ENG-SP18002-PDR-South-Redlines-V4.pdf Markup Summary

## Culvert Crossing at DP 10

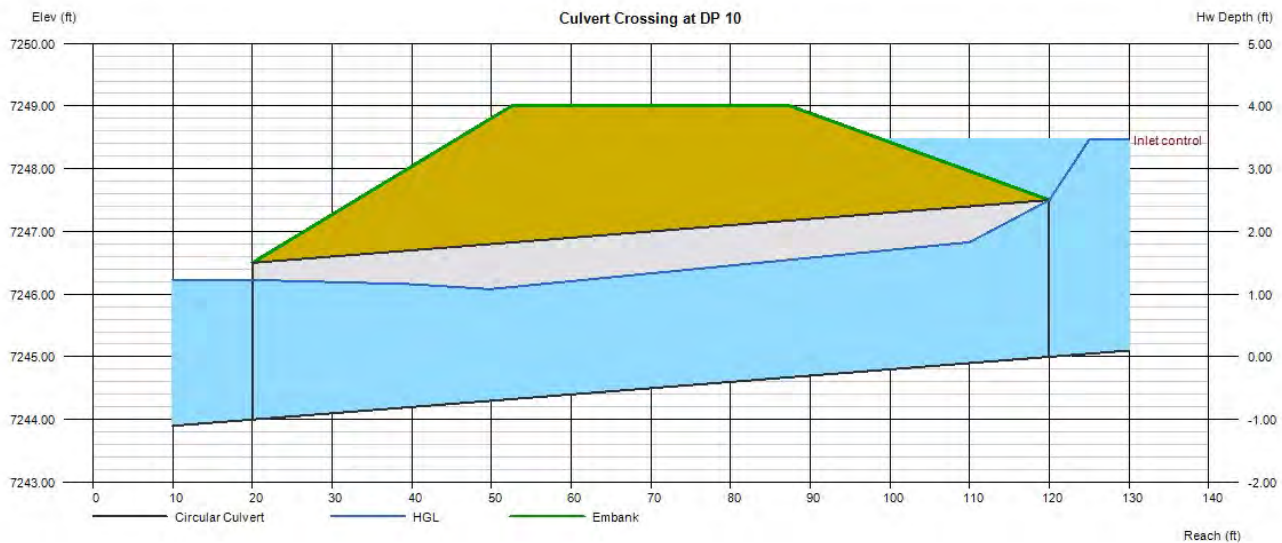
Provide culvert reports for culverts along the east side (see comment letter).
